Good morning Jeff;
This is in regards to the Coe Large Lot Subdivision LL-08-01. Mr. Coe has met all of the KRD requirements so this file is approved. If you need additional information, please let me know.

Thank you for the opportunity to comment on the notice of application for the 2 lot large subdivision on approximately 54.29 acres, proposed by Matt Coe [LL 08-01]. We have reviewed the application and have the following comments.

TO: Trudie Pettit, Community Development Services
FROM: Christina Wollman, Planner II *cw*
DATE: April 8, 2008
SUBJECT: Coe Large Lot Subdivision LL-08-01

**K.C.L.L.S.D. NO. 08-XX**  
**PART OF THE EAST 1/2, SEC. 8, T.18N., R.19E., W.M. KITTITAS COUNTY, WASHINGTON**

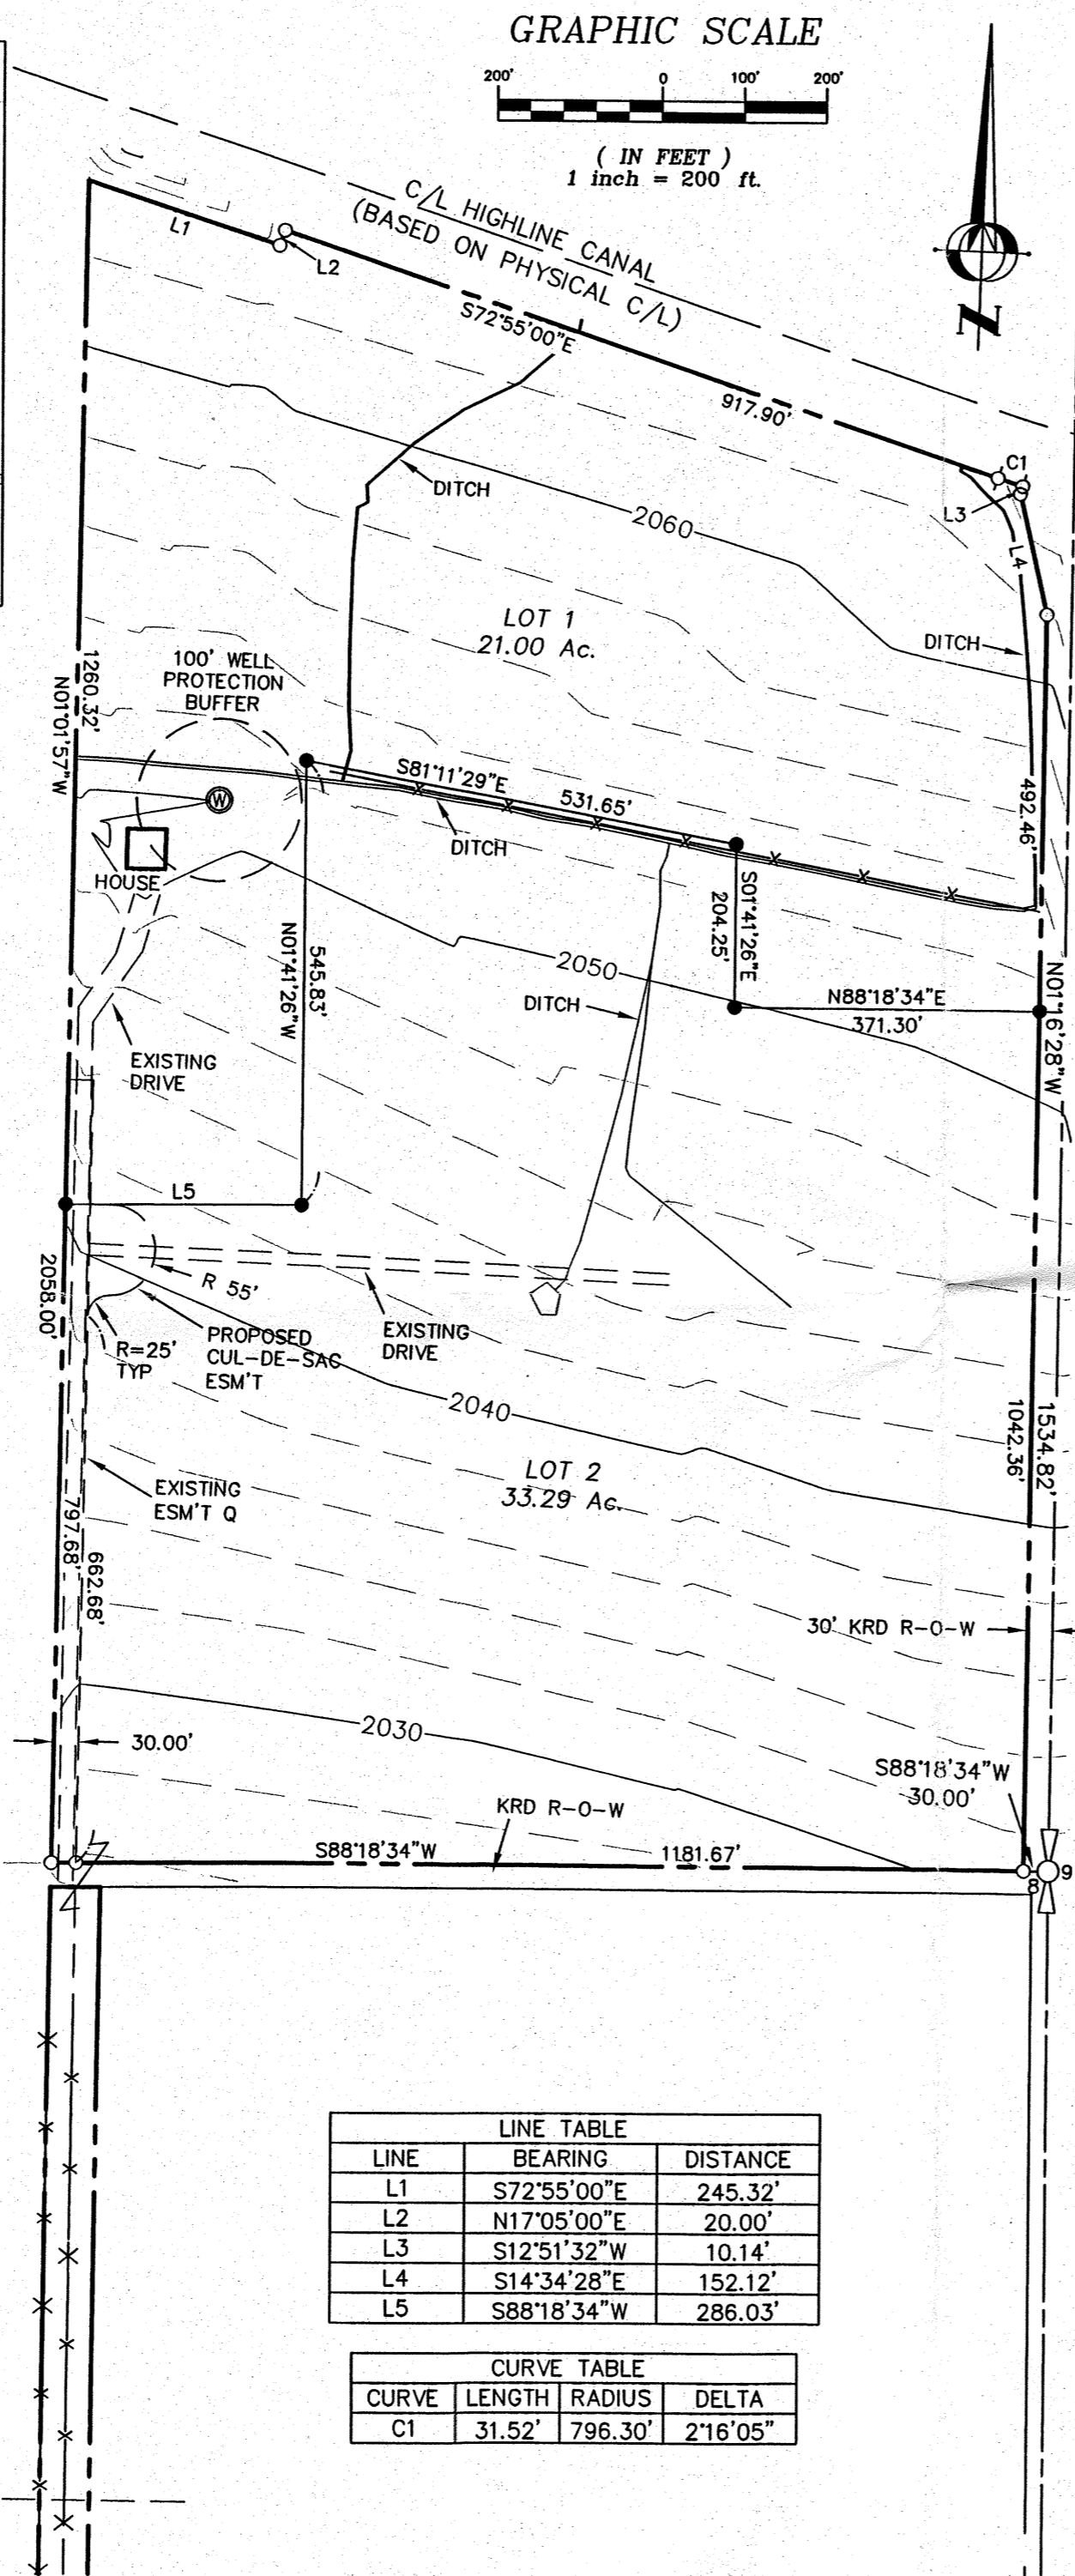
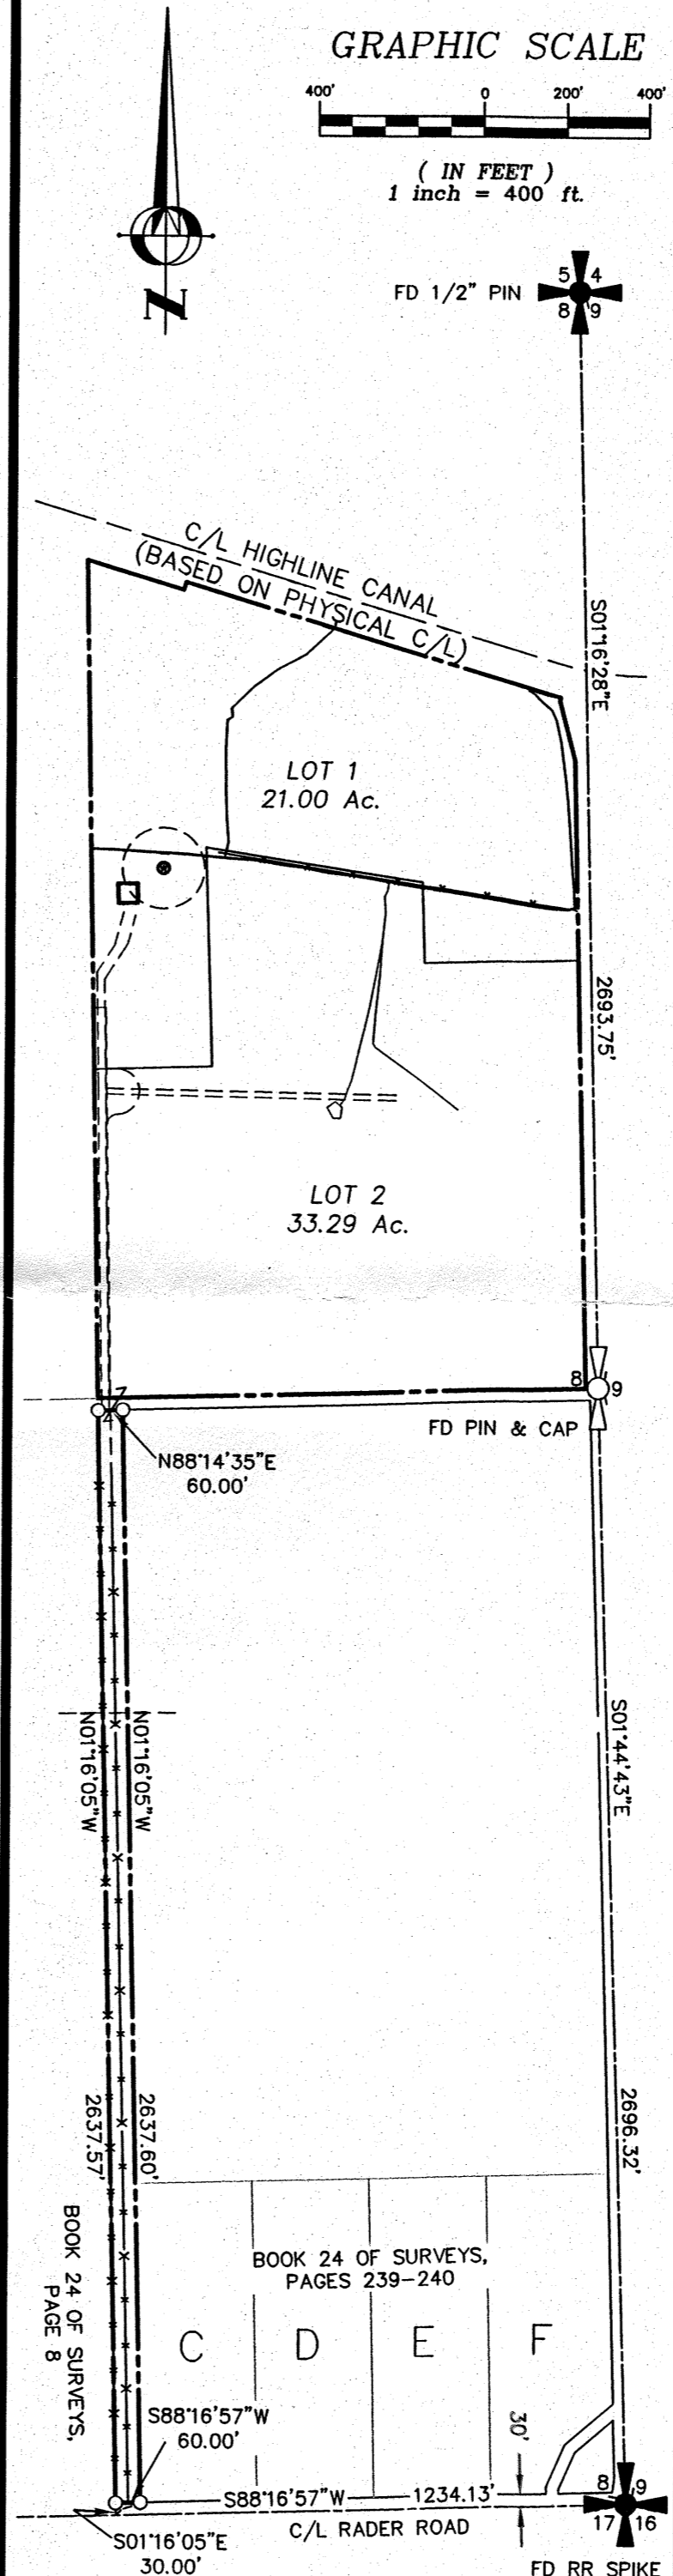
2. Adjacent Parcel Lines: The most recent survey for the parcels to the south is Book 34 Pages 42-43. The face of the survey shall be updated to reflect the correct adjacent parcel lines.

3. Access Easement: A 60' access easement is required from Rader Road to the cul-de-sac. A 55' radius cul-de-sac easement is required. The easement and any associated AFNs shall be shown on the face of the plat.

4. Private Road Improvements: Access from Radar Road to the cul-de-sac shall be constructed as a Low-Density Private Road. See Kittitas County Road Standards, 9/6/05 edition.
